KIRKLEES METROPOLITAN COUNCIL INVESTMENT & REGENERATION SERVICE

DELEGATED DECISION TO DETERMINE PLANNING APPLICATIONS

Reference No:	2023/62/91893/W
Site Address:	78, Marsden Lane, Marsden, Huddersfield, HD7 6AF
Description:	Removal of existing garage and link structure and erection of two storey side extension and raised terrace
Recommending Officer:	Sam Jackman

Officer Report – 2023/91893

Drg. no. **181-23-PL02** Rev. **C**

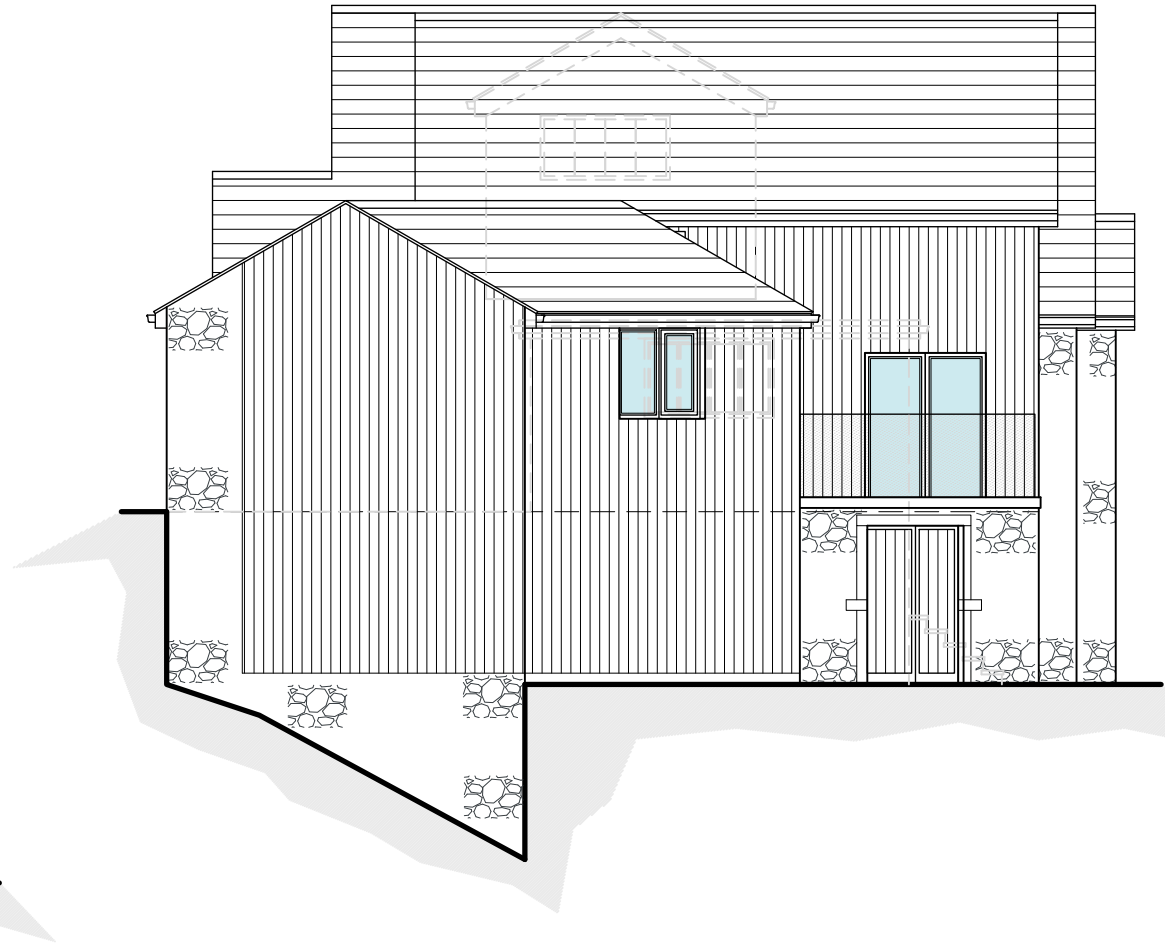
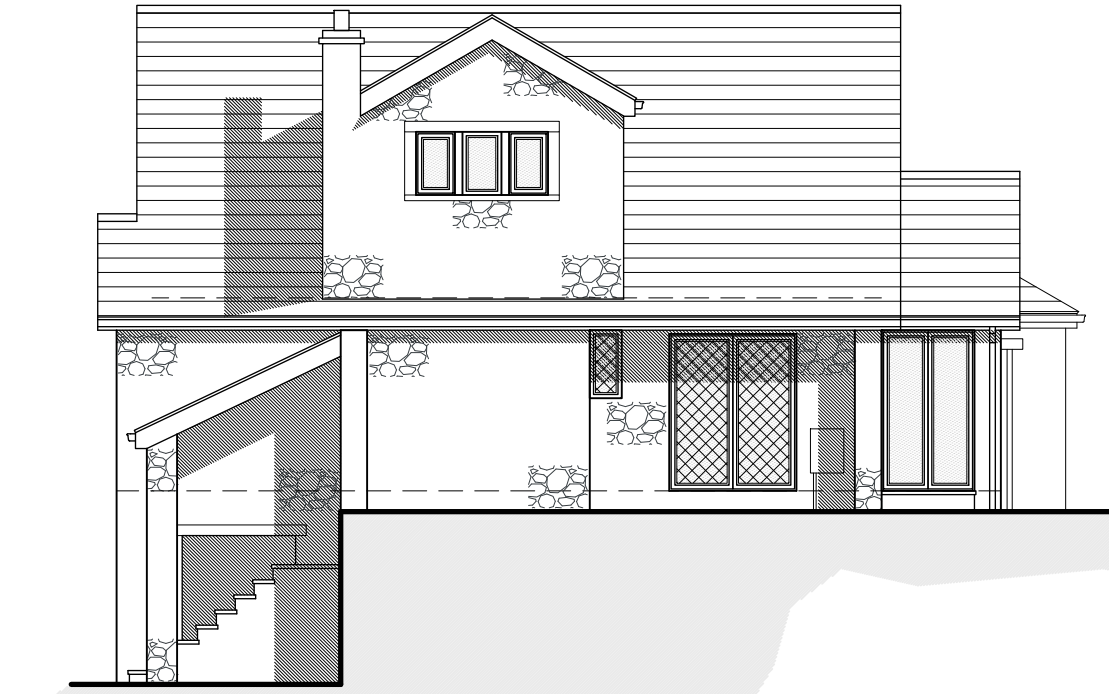
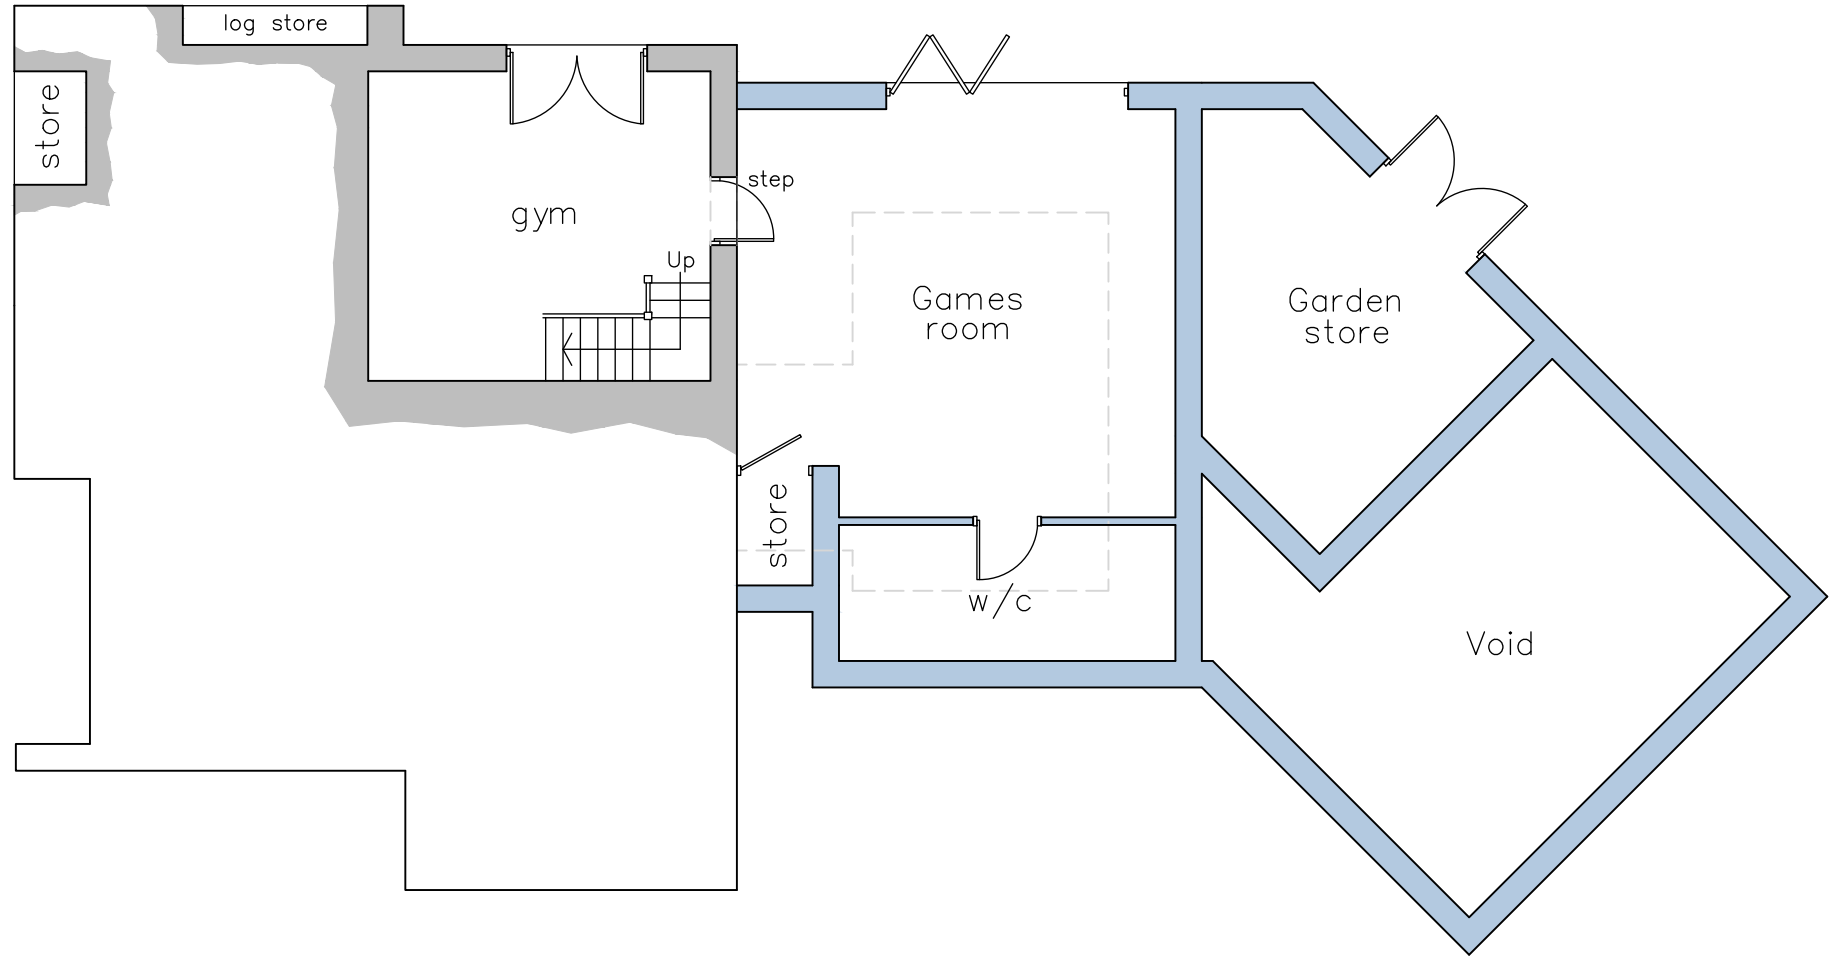
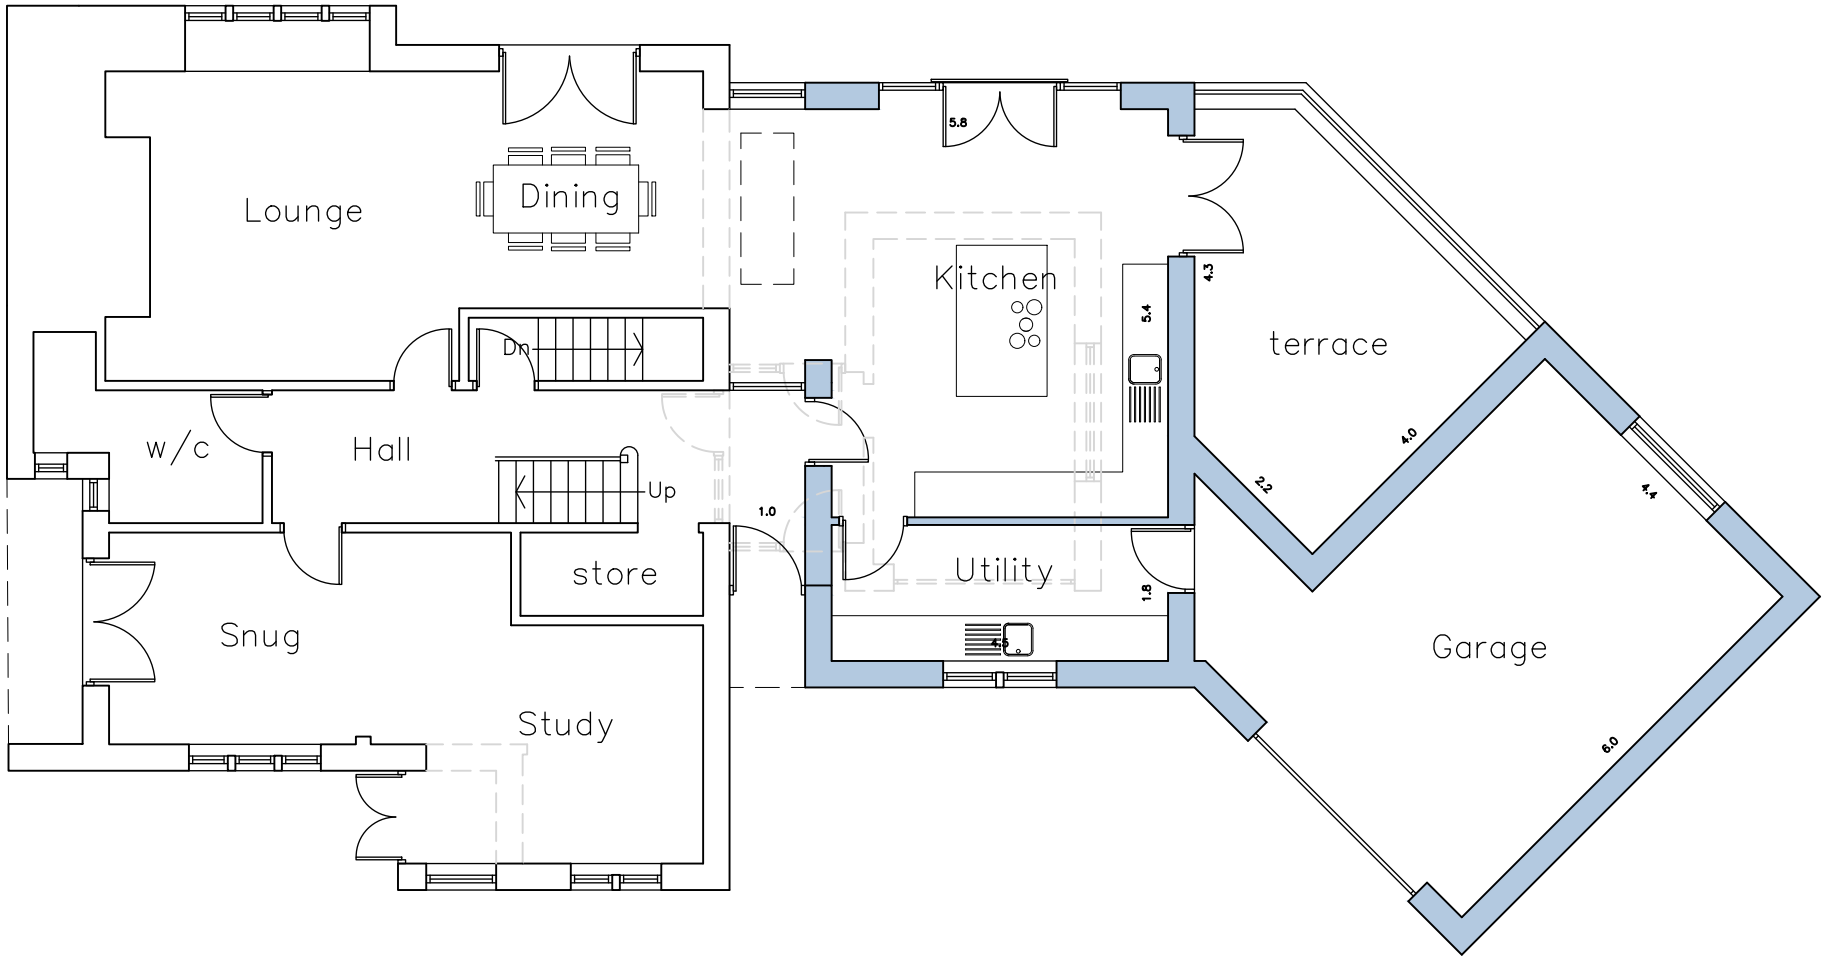
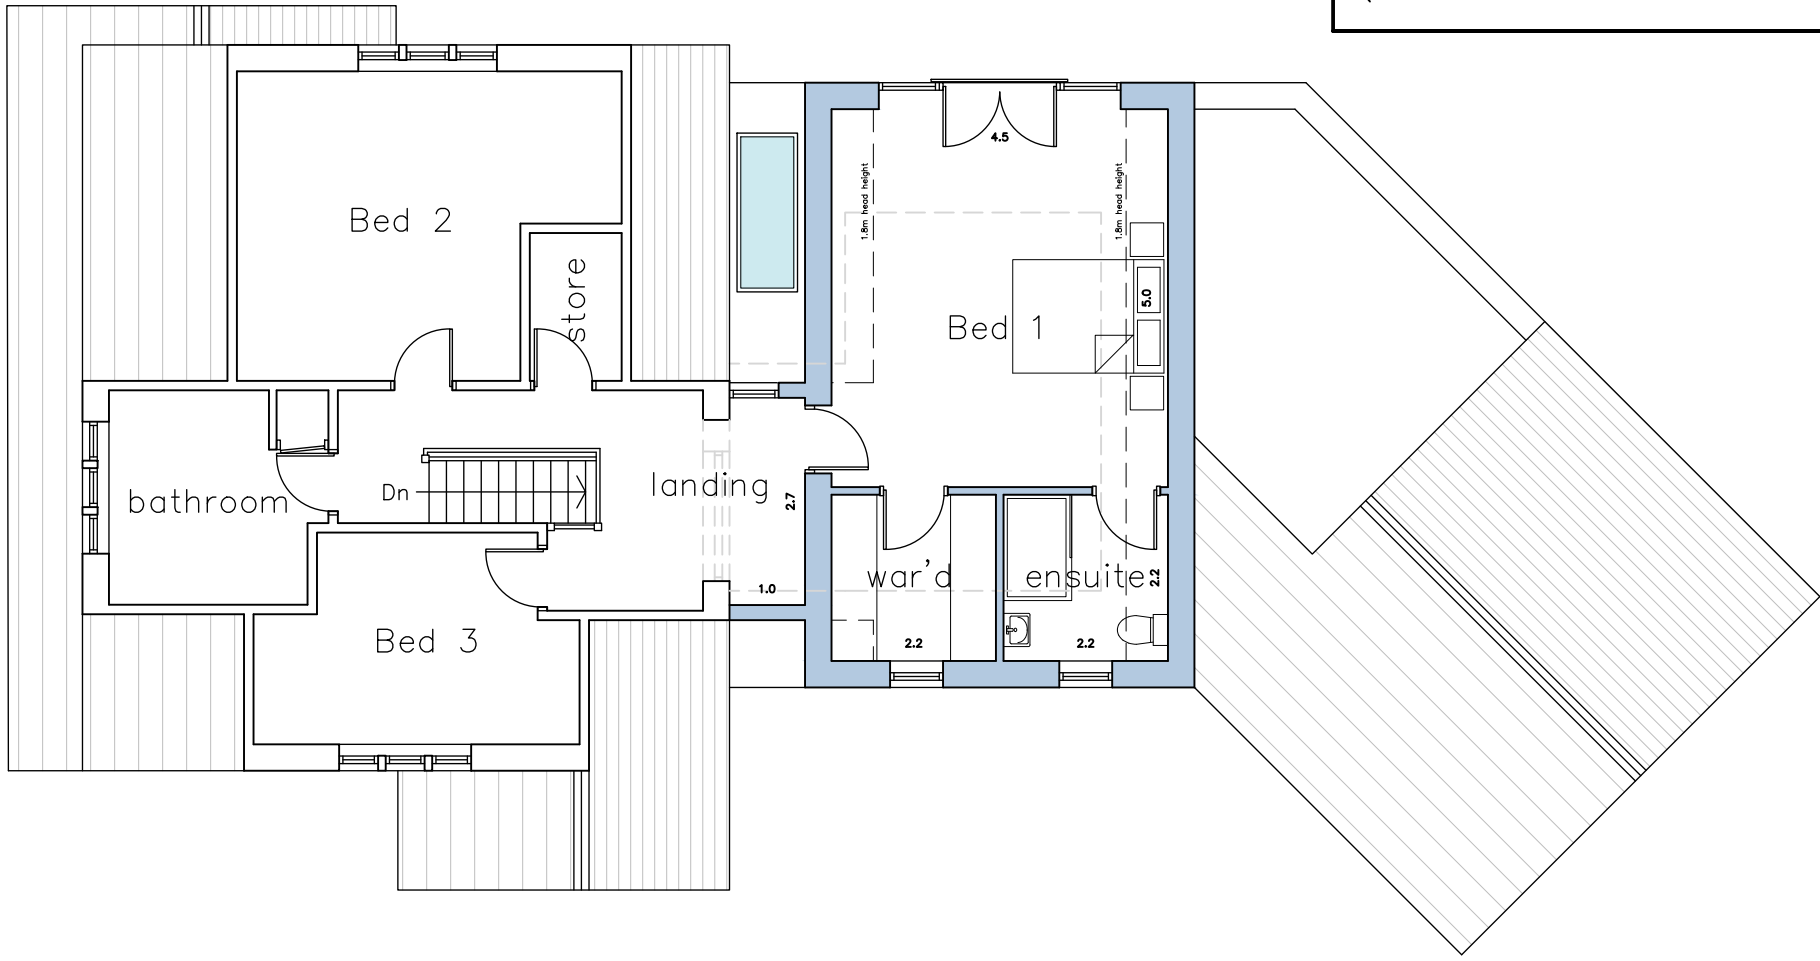
Negotiations have taken place with the agent due to the size and visual impact the proposal would have had on the residential & visual amenity of the area.
